CITY OF ALBUQUERQUE

September 18, 2012

Re: 3909 12th St. Office Improvements
Grading and Drainage Plan
Engineer's Stamp date 9-11-12 (G14/D083)

GRADING & DRAINAGE PLAN
SCALE: 1"=20'

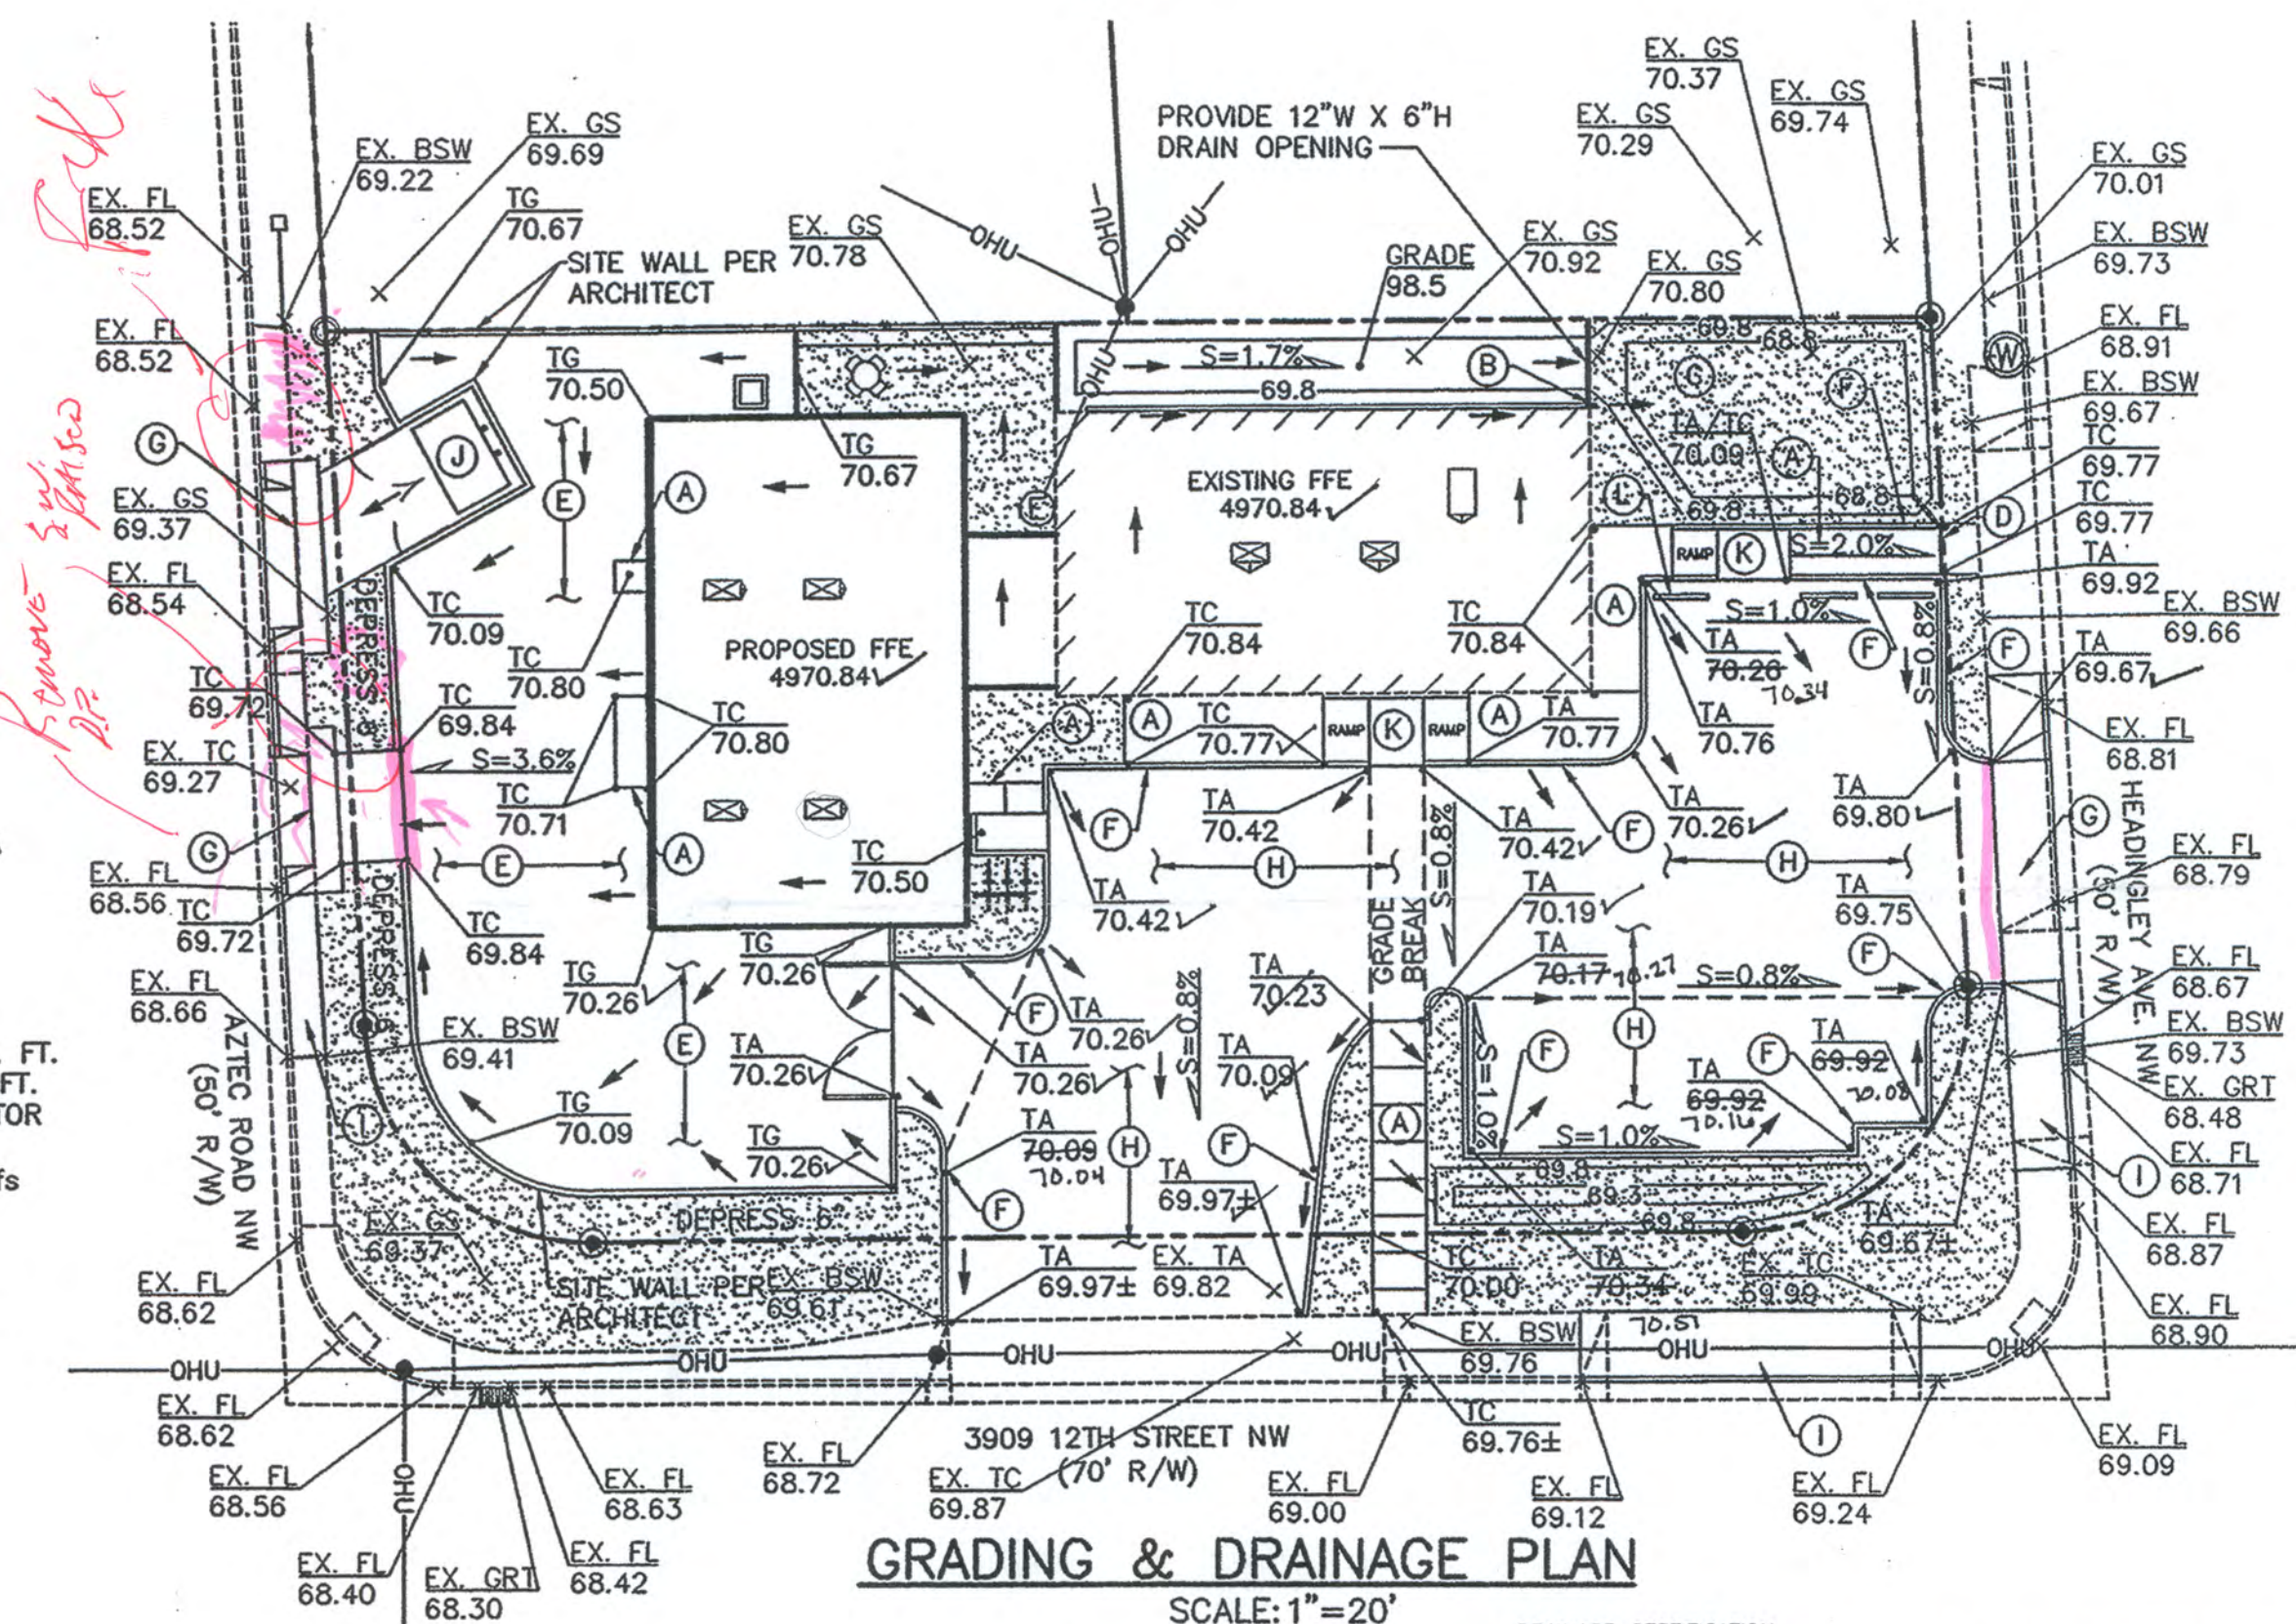
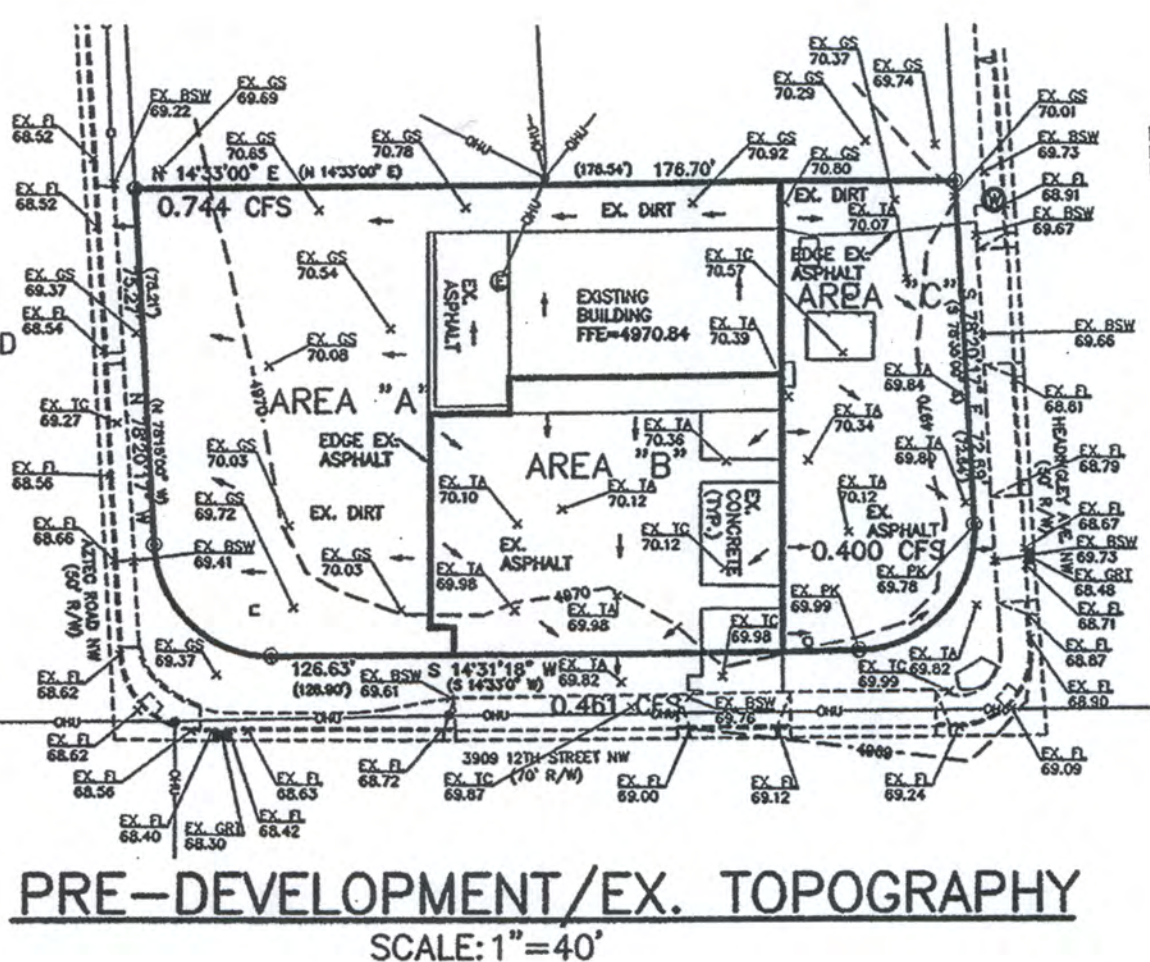
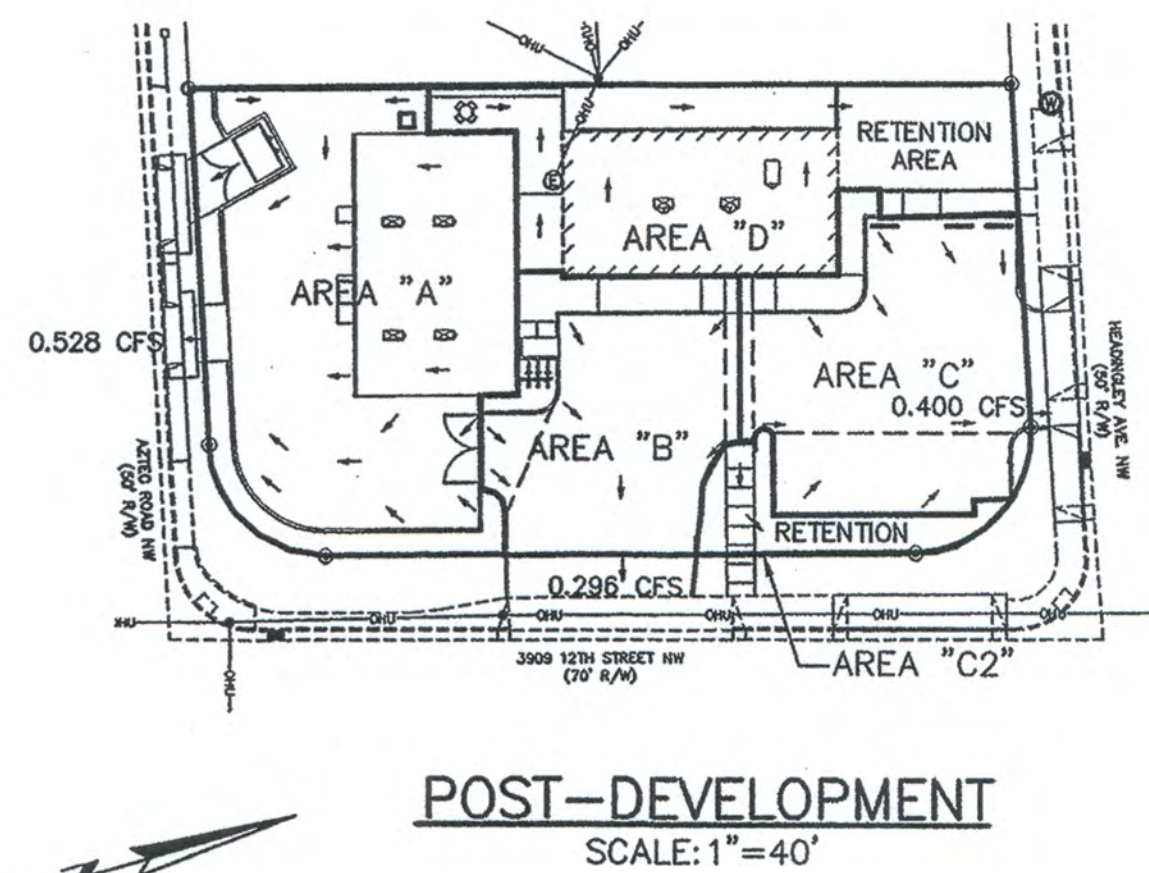
- A topographic map needs to be provided.
- Water blocks are needed at entrances/exits.
- Depress all landscape areas.
- Spot elevations are needed for the properties to the west.
